From: Charlotte Burrows
Sent: 04 December 2014 14:50
To: 'Jack Dowling'
Subject: RE: Further Information Required on Your Ref: PP-03776562 Our Ref: FP/199/14/HH

Existing Front Elevation

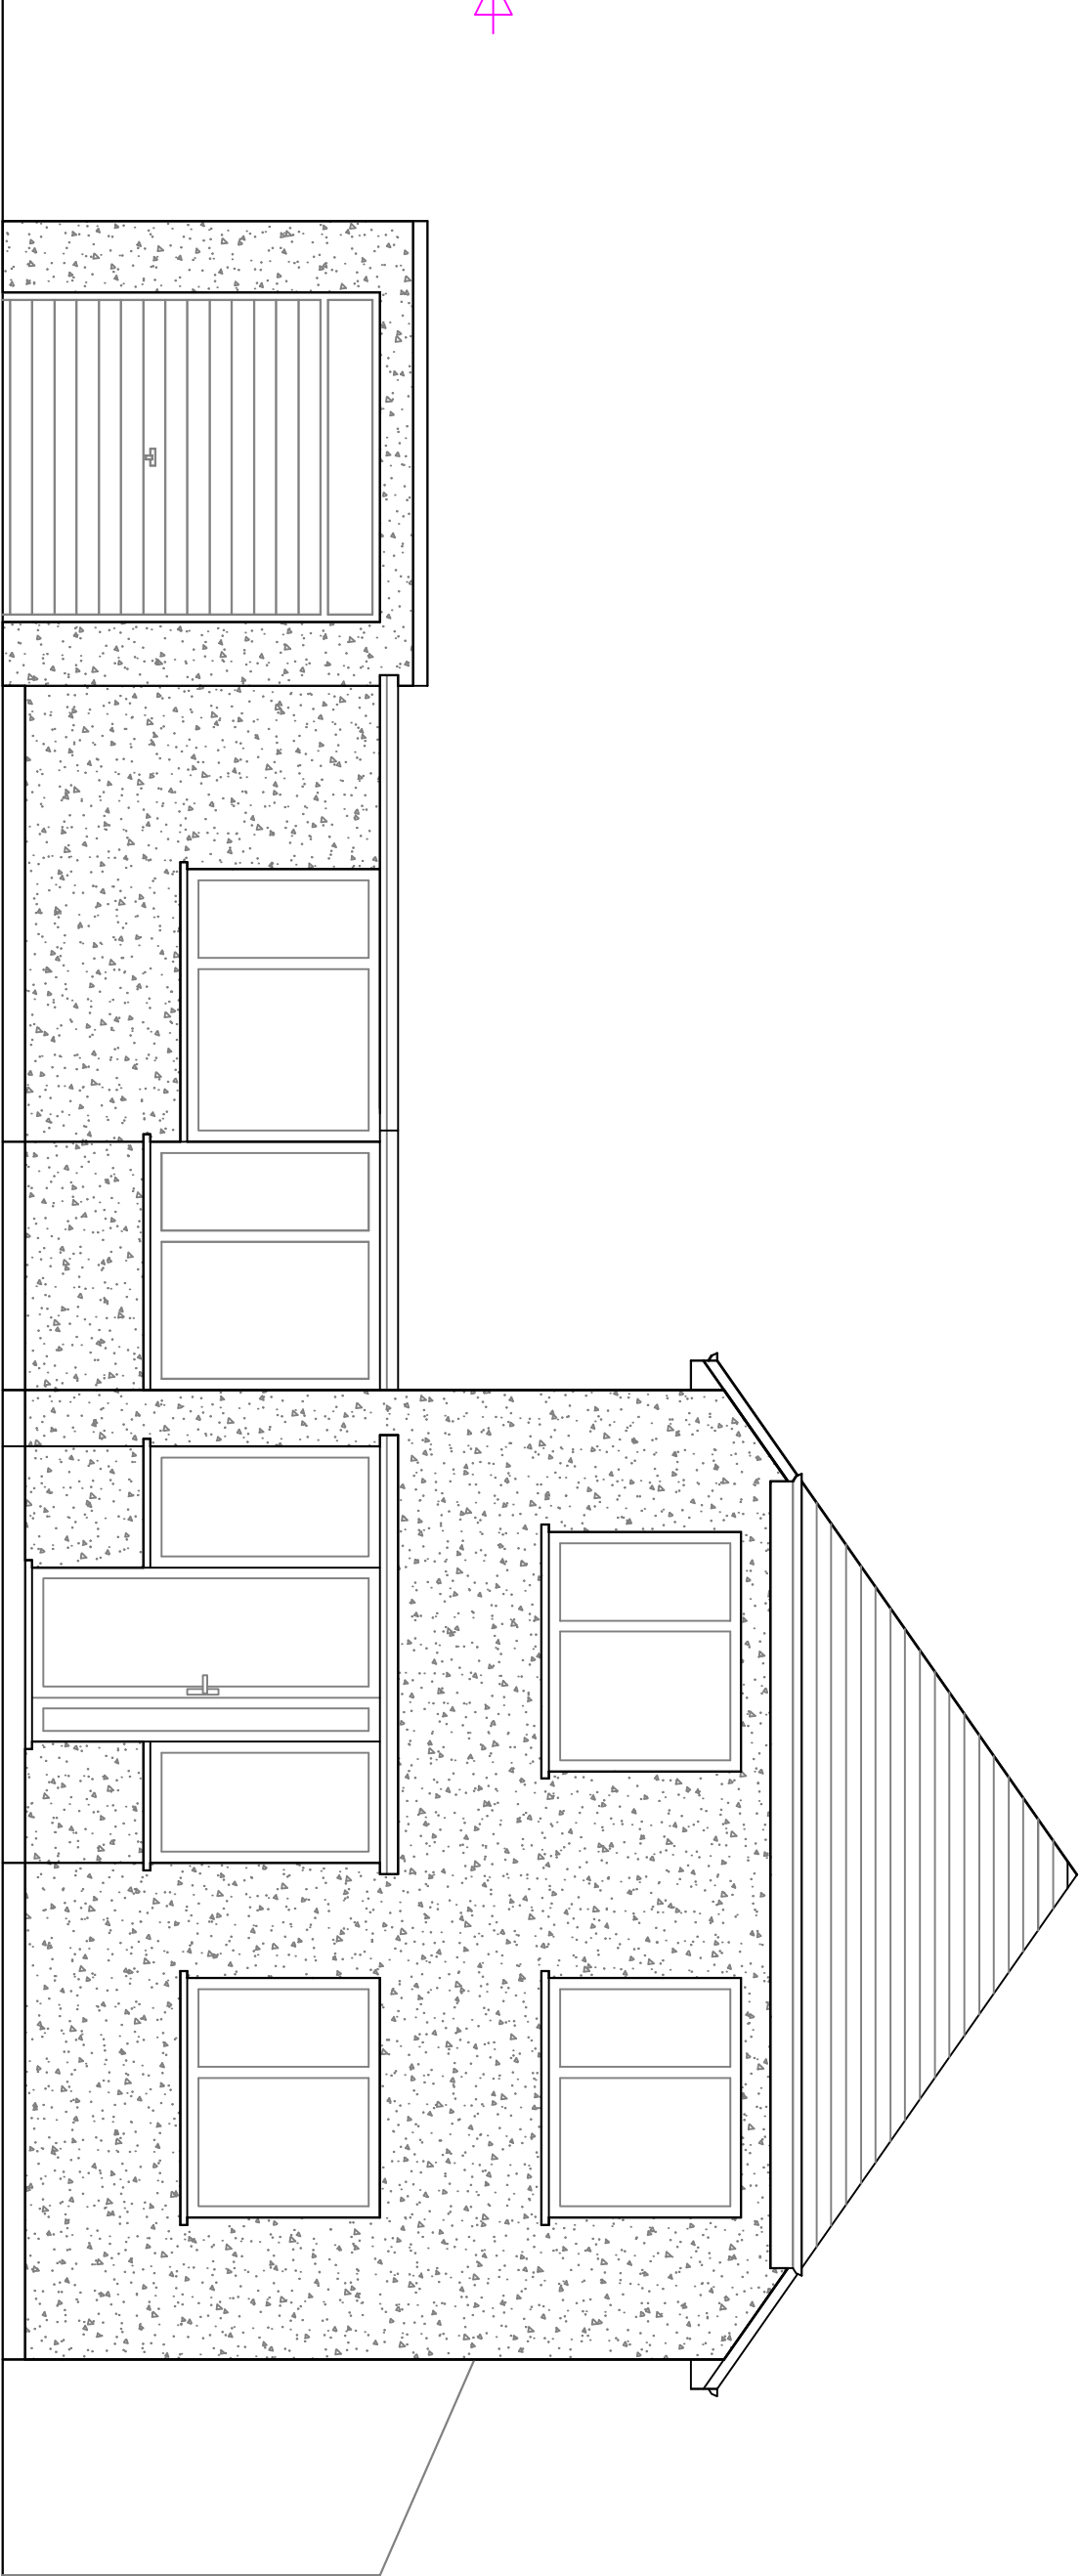
Unfortunately there appears to be some discrepancies on the existing and proposed floor plans, on the front and rear of the floor plans you have indicated a small door (right hand side of the plan), although these doors haven't been indicated on the elevations.
